COMMUNITY DEVELOPMENT DEPARTMENT
80 Columbia Avenue ♦ Marysville, WA 98270
(360) 363-8100 ♦ (360) 651-5099 FAX

Re: Quality Auto Center – *Tech Review 1*
PA22005

After preliminary review of the above referenced proposal, the Planning Division has the following comments:

A1.1

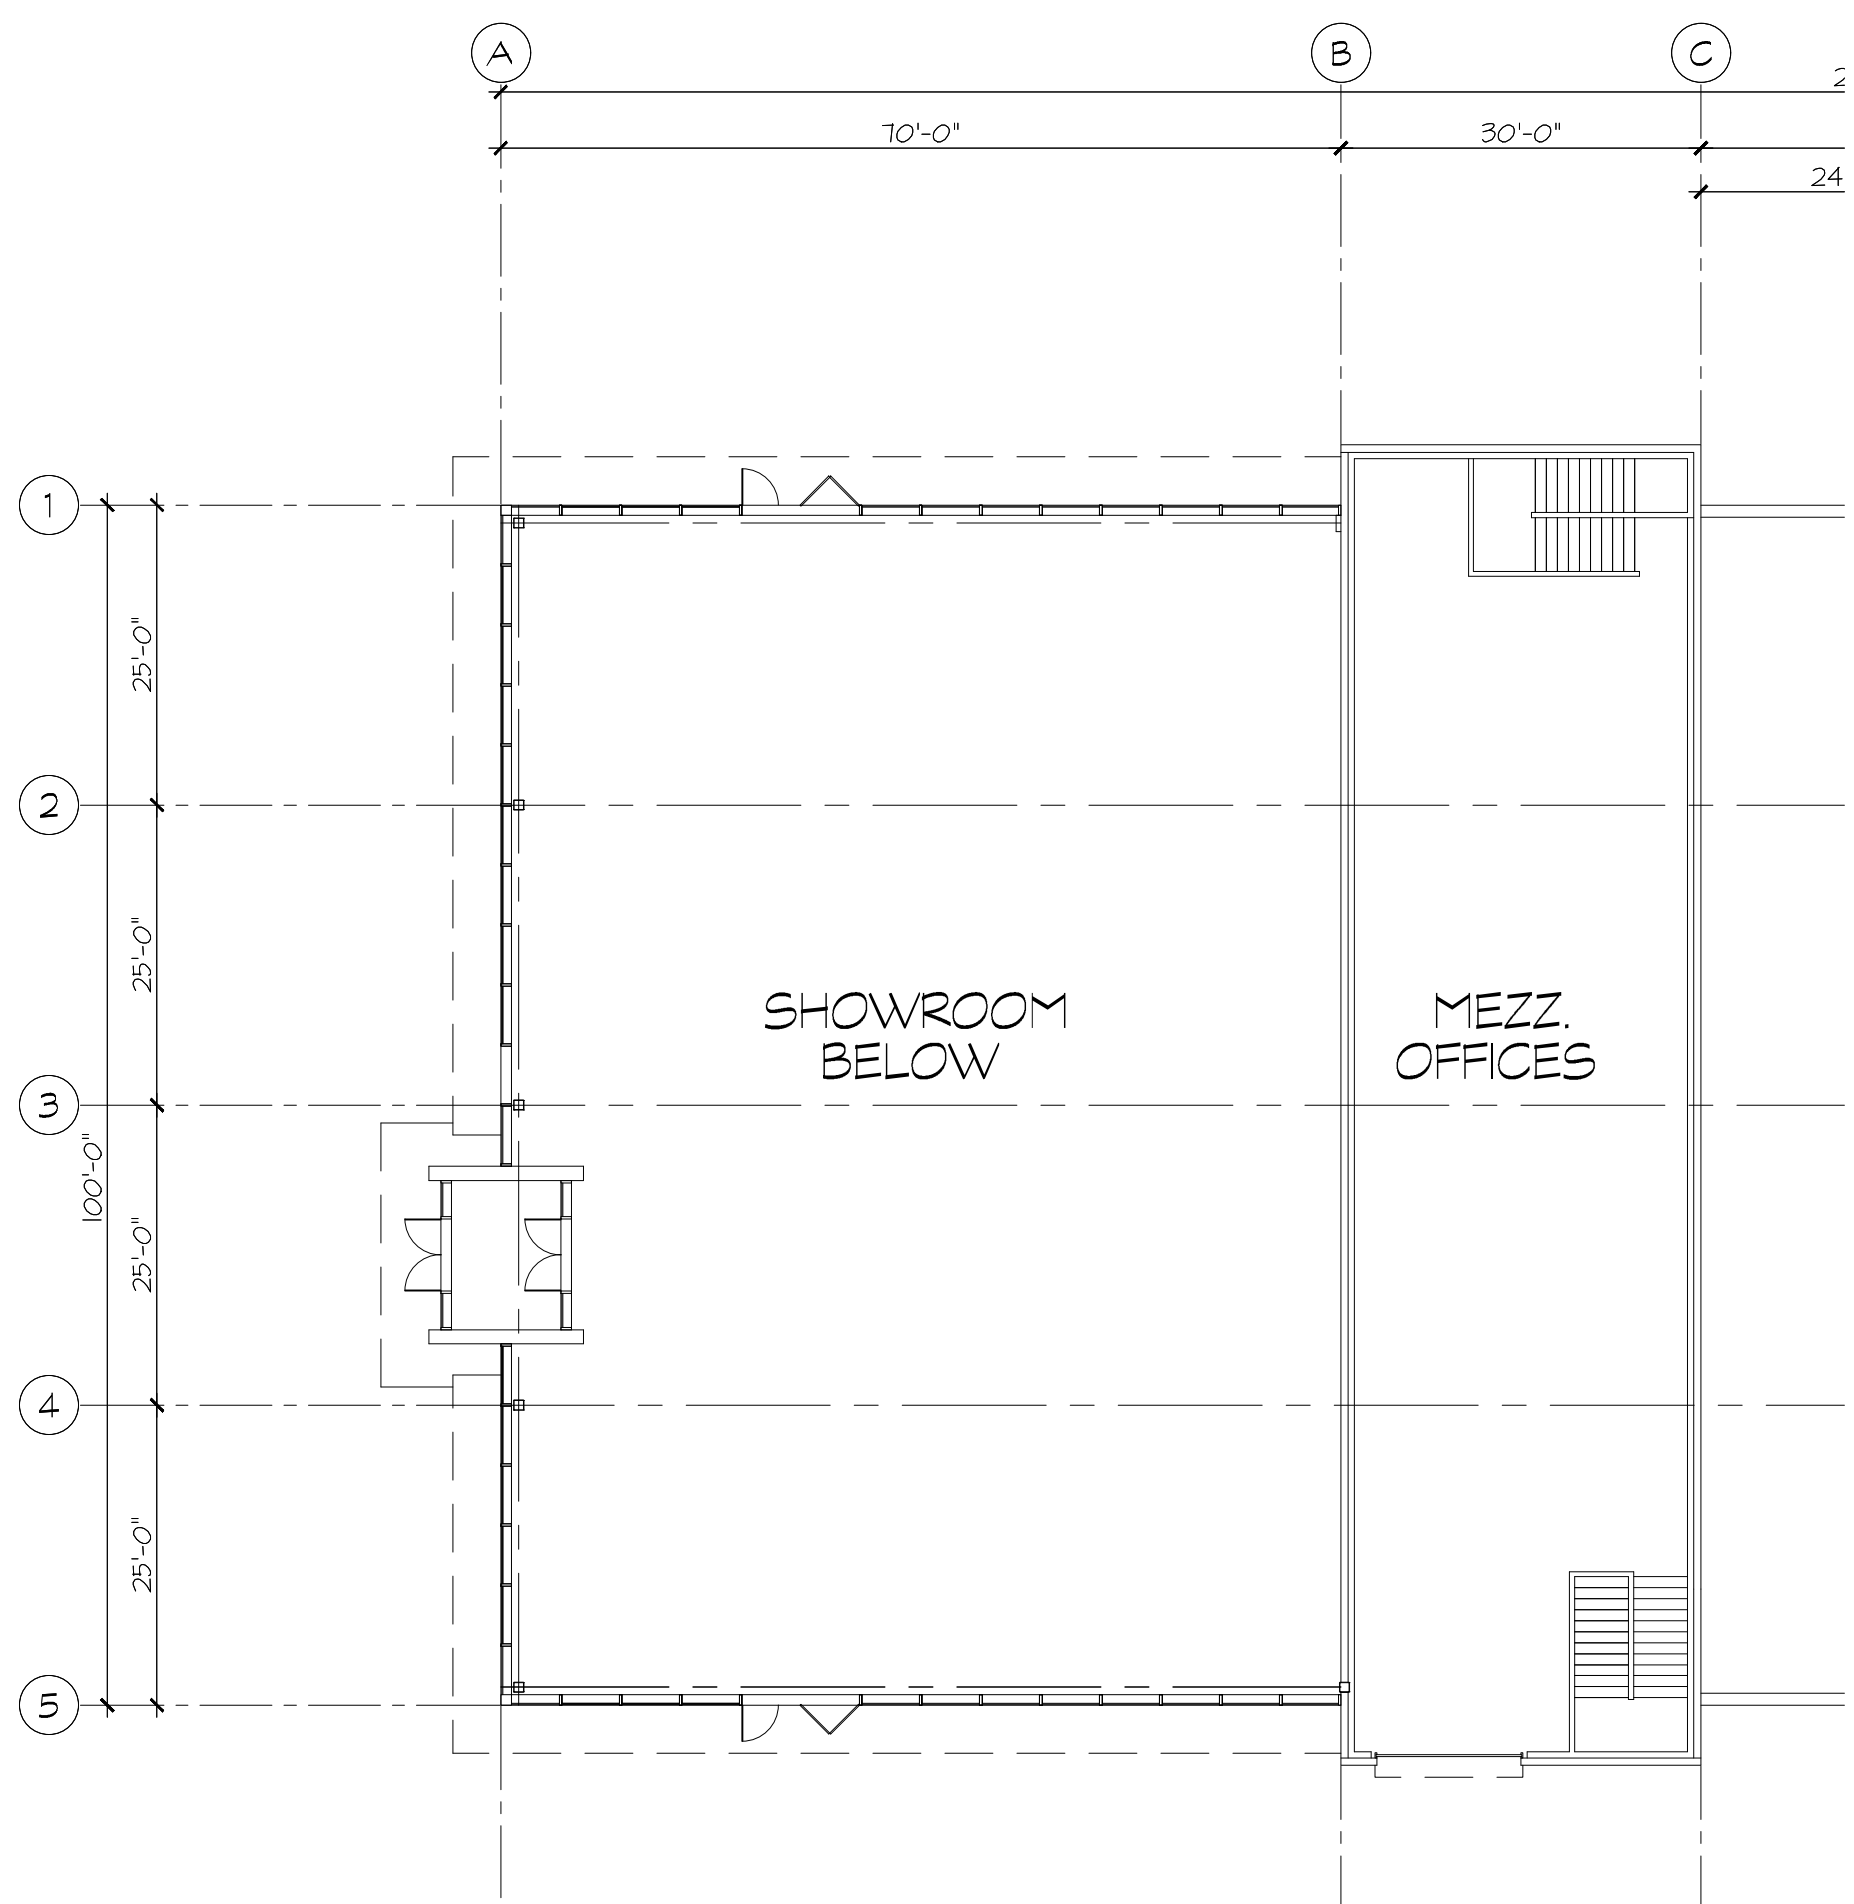
4. Sheet A1.1: The autoturn analysis provided appears to show that car carrier truck and trailer would need to mount the landscape islands and travel into designated parking areas, or inventory lot to make the necessary movements for pick-up and delivery. The site plan will need to be amended to ensure the truck and trailer can navigate through the site without impacting landscape islands and designated parking areas, or the inventory lot.

PRELIMINARY SITE PLAN

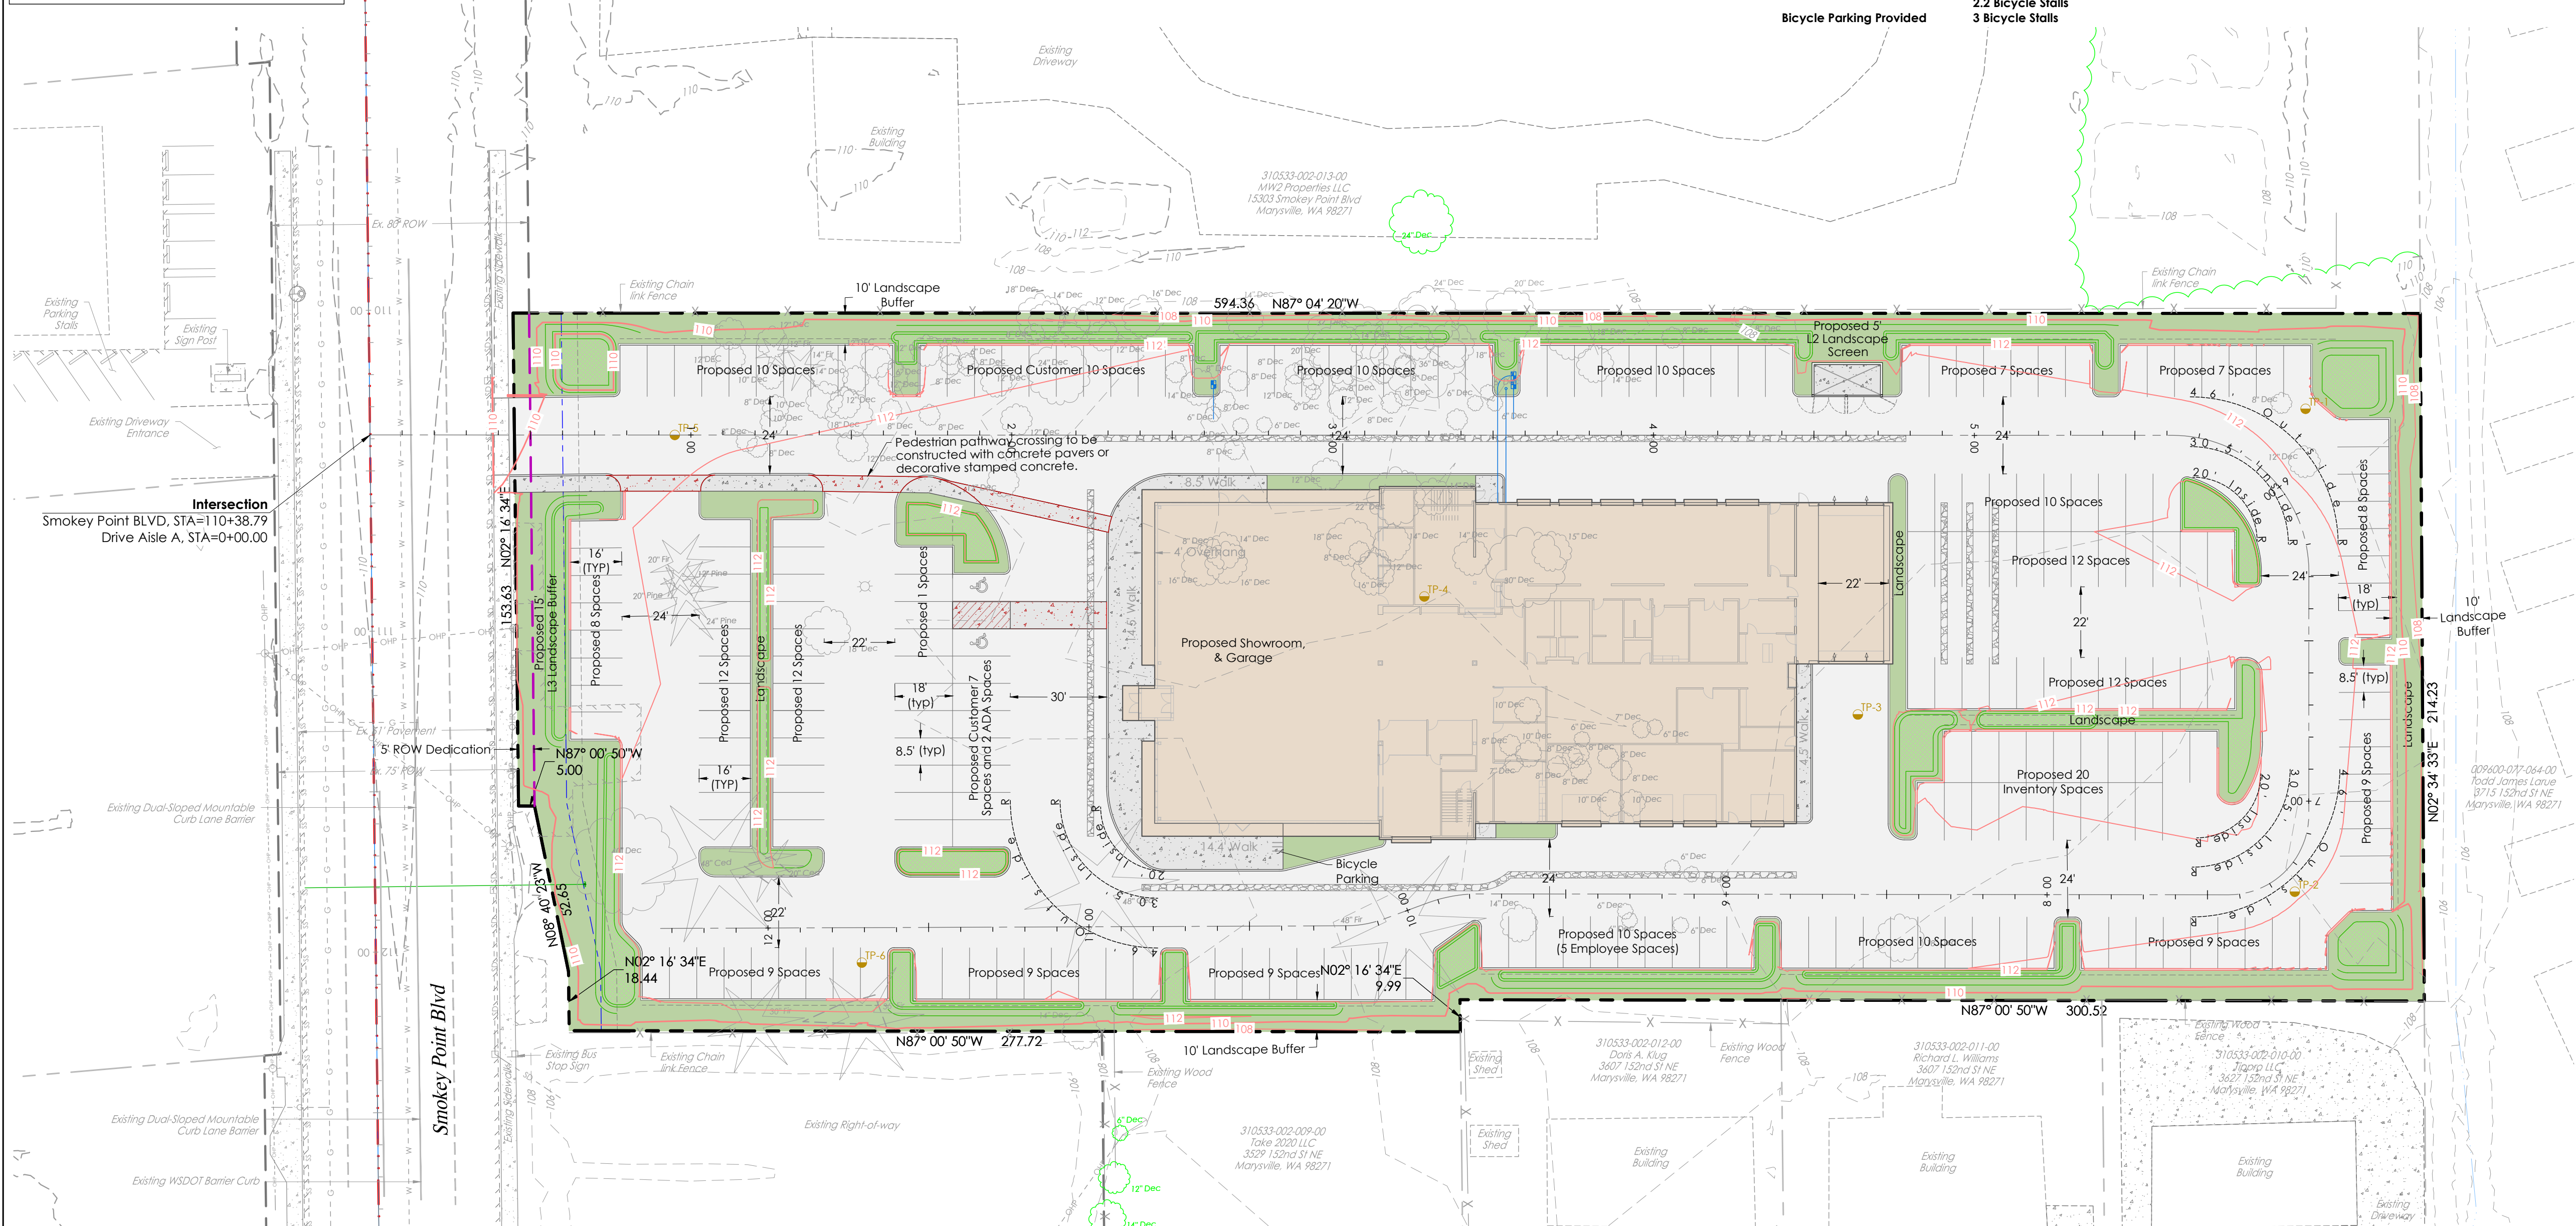
3. Sheet P1 shall be amended, as follows (see attached redlines):
 - a. The pedestrian connection shall be relocated to align with the front entry to the showroom to the sidewalk. Pursuant to [MMC 22C.130.050](#)(5)(c), the pedestrian pathway shall be constructed with decorative concrete and physically separated from vehicle traffic and maneuvering areas.

A minimum 5' landscape islands shall be provided on either side of the pedestrian pathway as it traverses through the proposed parking spaces and/or inventory lot.
 - b. Provide turning radii, demonstrating compliance with the following:
 - Turning radii - 20' (inside)
 - Turning radii (fire/solid waste) - 30.5' (inside) 46' (outside);
 - c. Amend SIGNS language to read as follows:
 - All signs ~~shall are to~~ comply with MMC ~~Chapter 22C.160 Signs~~~~22C.160.160(1)~~.
 - d. Under NOTES, remove notes d, e, f and g, and add the following notes:
 - Prior to civil construction plan approval, the applicant shall be required to demonstrate compliance with the applicable landscaping standards outlined in [MMC 22C.020.250](#)(4).
 - Prior to building permit issuance, the applicant shall be required to demonstrate compliance with the Site Design Utilizing Crime Prevention
